M3 Junction 9 Improvement Scheme

7.12.7 Statement of Common Ground with Cycle Winchester (Rev 1)

**7.12.7 STATEMENT OF COMMON GROUND WITH CYCLE
WINCHESTER**

This Statement of Common Ground has been prepared and agreed by (1) National Highways Company Limited and (2) Cycle Winchester

DRAWING TITLE  
 FIGURE 2.6 - THE SCHEME: TEMPORARY DIVERSION OF WALKING, CYCLING, AND HORSE RIDING ROUTES APFP REGULATIONS 5(2)(a) DOCUMENT REFERENCE 6.2

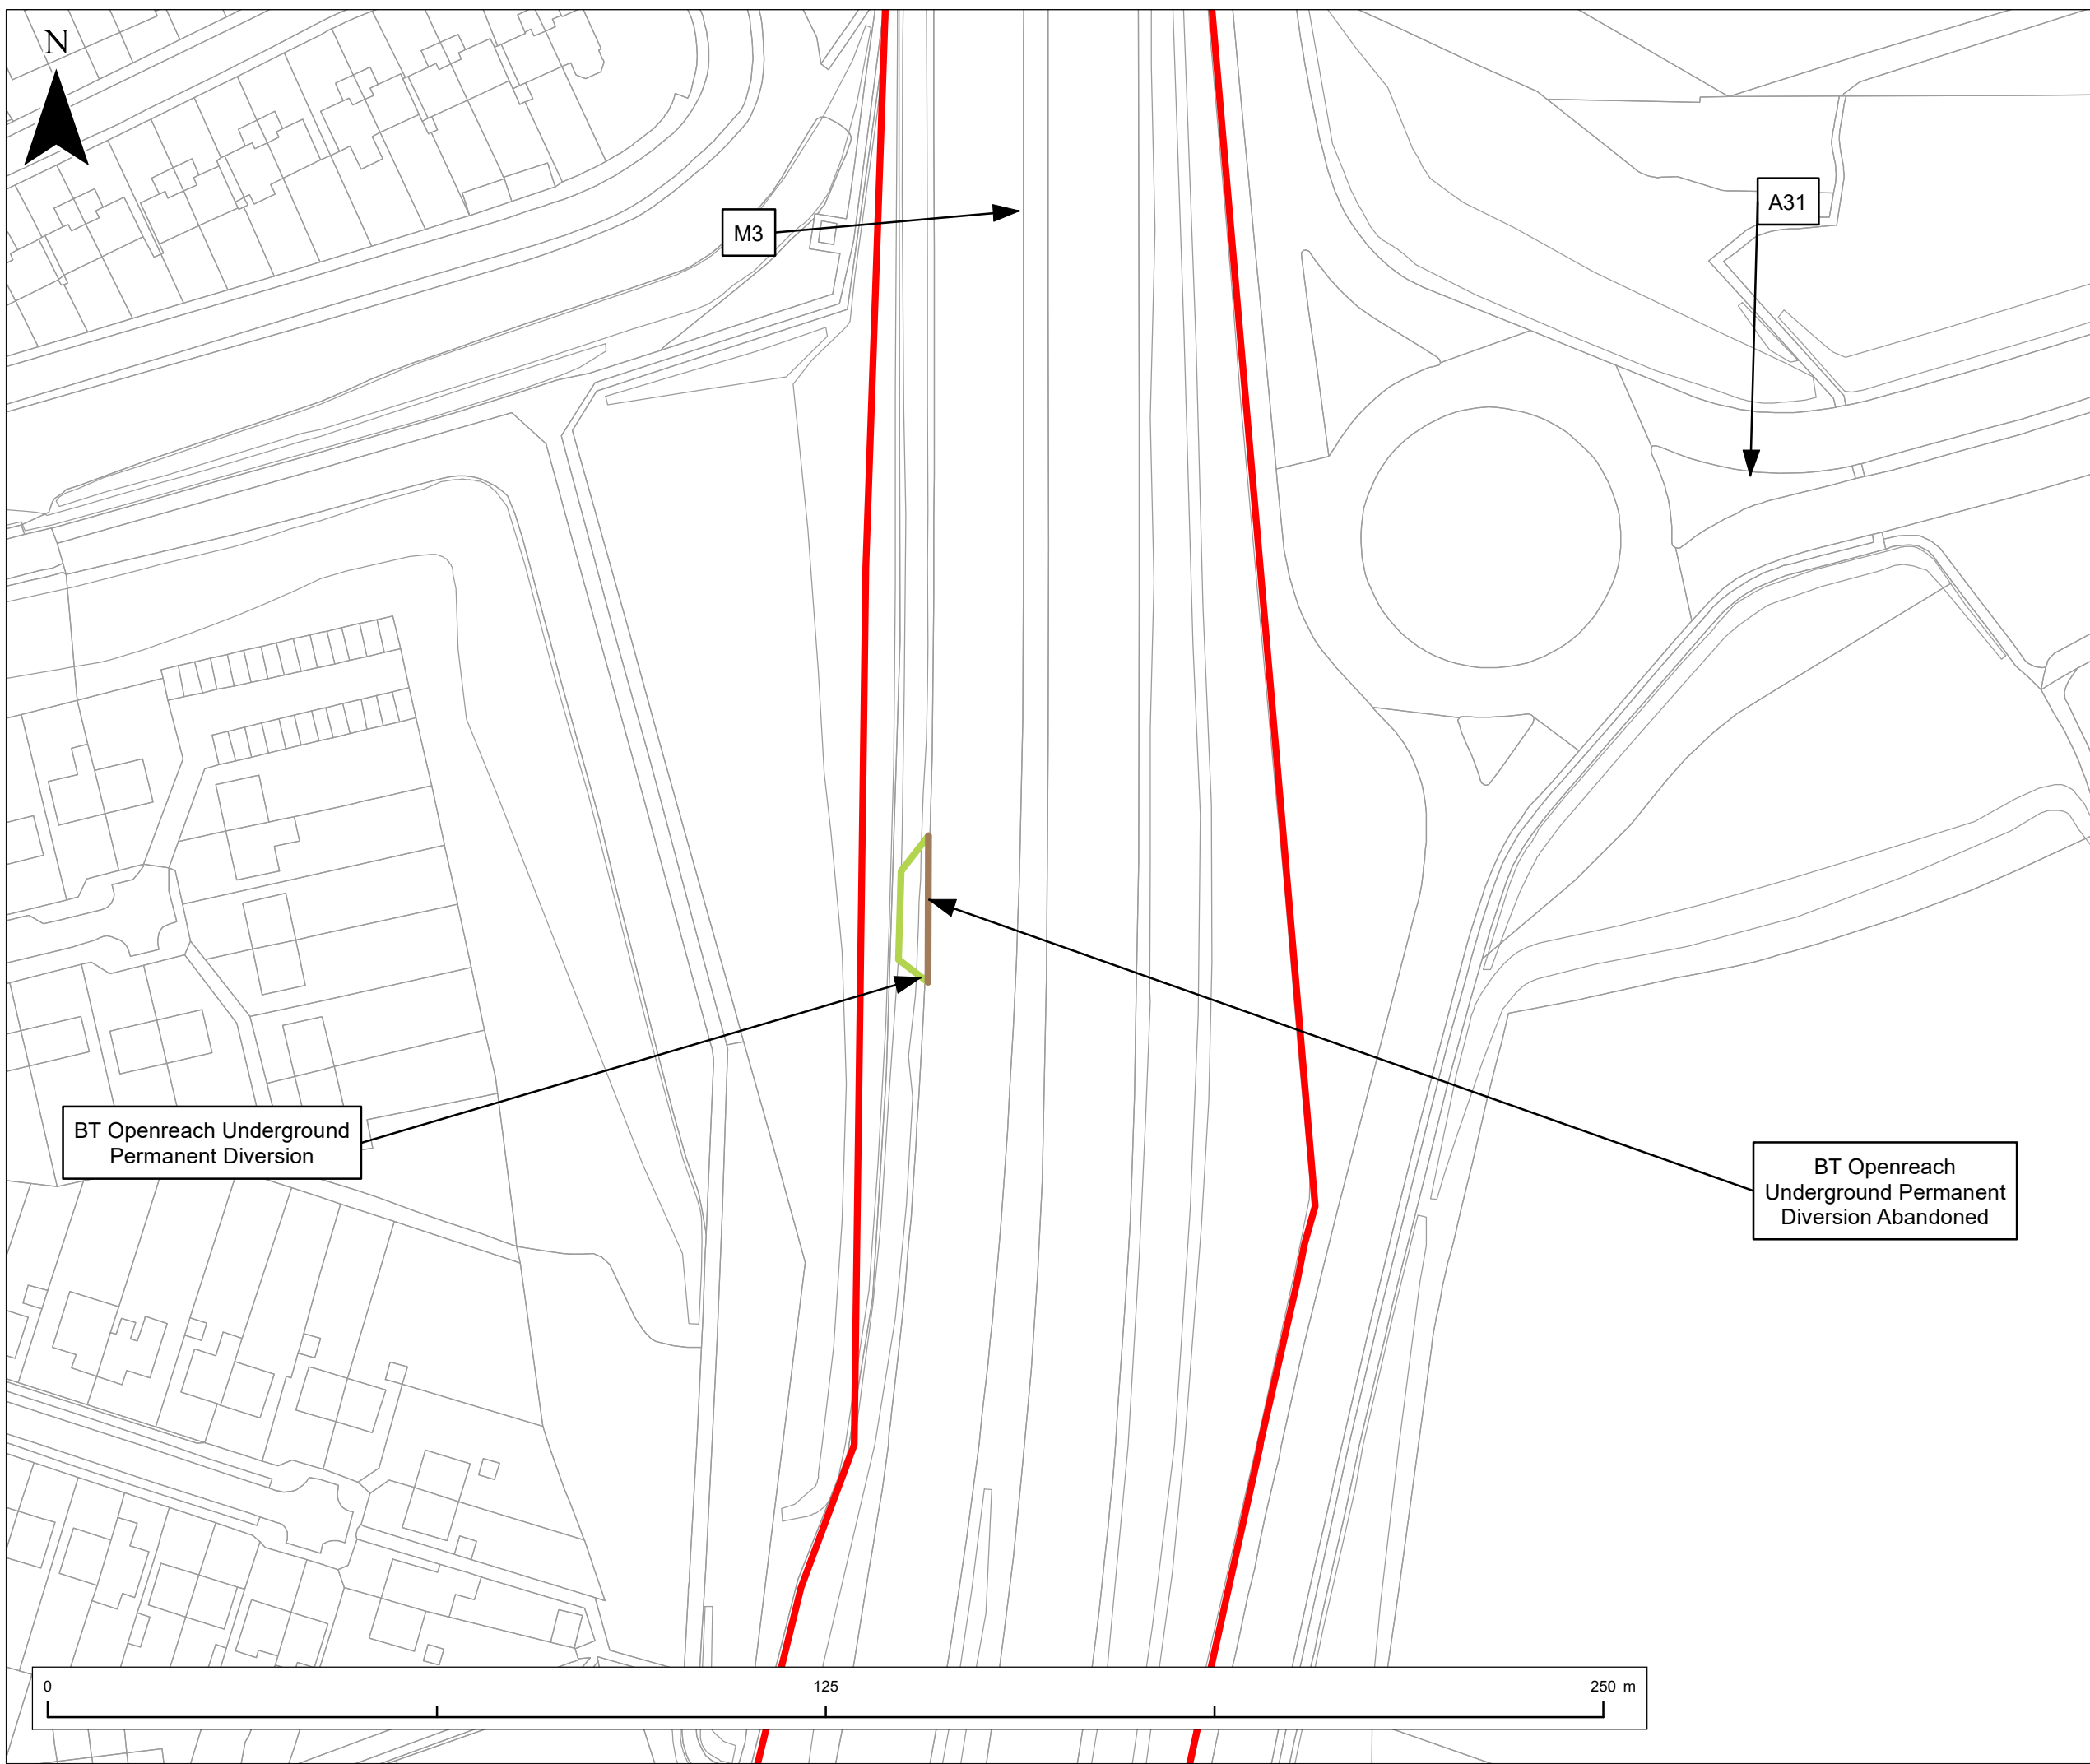
5. Traffic Management Plan						
5.1	NCN Route 23 Diversions during construction	Figure 2.6 (Temporary diversion of walking, cycling and horse-riding routes) of	Although the NCN23 route is not used to its full potential, it is heavily used by local cyclists and alternative routes will be needed and mitigation measures required. The diversion route	Figure 2.6 (Temporary diversion of walking, cycling and horse-riding routes) of Chapter 2 (The Scheme and its Surroundings – Figures (Part 3 of 4)) of the ES (6.2, APP-063) shows	Not agreed	8 November 2023

Reference	Issue	Document References (if relevant)	Cycle Winchester's Position	National Highways' Position	Status	Date
		<p>Chapter 2 (The Scheme and its Surroundings – Figures (Part 3 of 4)) of the ES (6.2, APP-063) and Chapter 12 (Population and Human Health) of the Environmental Statement (ES) (6.1, Rev 1)</p>	<p>proposed in the DCO submission (Table 12.25 of Chapter 12 (Population and Human Health) of the Environmental Statement (ES) (6.1, APP-053)), although legal, is unsuitable for cyclists and equestrians to use. Despite many opportunities (and many requests), the National Highways project team failed to discuss it with the WCH consultative group before submitting the proposal. There's no way Cycle Winchester can agree to it.</p> <p>Two possible diversion routes are:</p> <ul style="list-style-type: none"> ▪ Long Walk, Fair Lane and Alresford Road (B3404), and ▪ Easton Lane and Martyr Worthy Road (B3047). <p>Alresford Road is busy and hostile to cyclists and so National Highways should be looking at funding mitigation measures to make it more suitable as an alternative cycle route. Cycle Winchester note that the project team considers Alresford Road to be a safe diversion route without further mitigation. Based on real-world experience, we disagree. It is a busy road with fast-moving traffic, relatively narrow vehicle lanes and no cycle facility. While it is true that some short sections of NCN Route 23 use national speed limit roads, these are all quiet country lanes with very low traffic levels and physical characteristics that make high driving speeds impossible in practice.</p> <p>Cycle Winchester would like to see an open discussion of diversion routes and agreement on appropriate routes, projected timescales, diversion management, and mitigation needed to make those diversions practical for the wide range of cyclists who currently use the route.</p>	<p>two temporary diversion routes for NCN Route 23.</p> <p>Paragraph 12.8.11 and table 12.25 in Chapter 12 (Population and Human Health) of the Environmental Statement (ES) (6.1, APP-053) was updated at Deadline 4 to make the diversion routes clearer.</p> <p>The route for cyclists diverted from the eastern side of the gyratory during construction phases 1 and 2 would be along Long Walk, Fair Lane and then west on Alresford Road as per the first suggested option in the comment. Neither of the diversion routes are illegal or impossible for cyclists and equestrians to use and National Highways does not consider it necessary to undertake any works before they can be used.</p> <p>The diversion route on Alresford Road contains an approximately 100m stretch at national speed limit before the limit decreases to 40mph. The diversion route for NCN Route 23 will be clearly signposted and monitored and checked during its implementation. Further mitigation is not needed for this diversion on the basis that the NCN Route 23 contains sections of national speed limit roads throughout its route already. Mitigation will be reviewed during construction and implementation of the diversion route.</p> <p>As outlined in the Outline Traffic Management Plan (7.8, Rev 2), updated at Deadline 5, National Highways commit to producing a PRow Management Plan during detailed design. National Highways will have regard to Cycle Winchester's views during the development of the PRow Management Plan during detailed design. This will include controls to manage the crossing of the haulage route and NCN Route 23 and on Long Walk.</p>
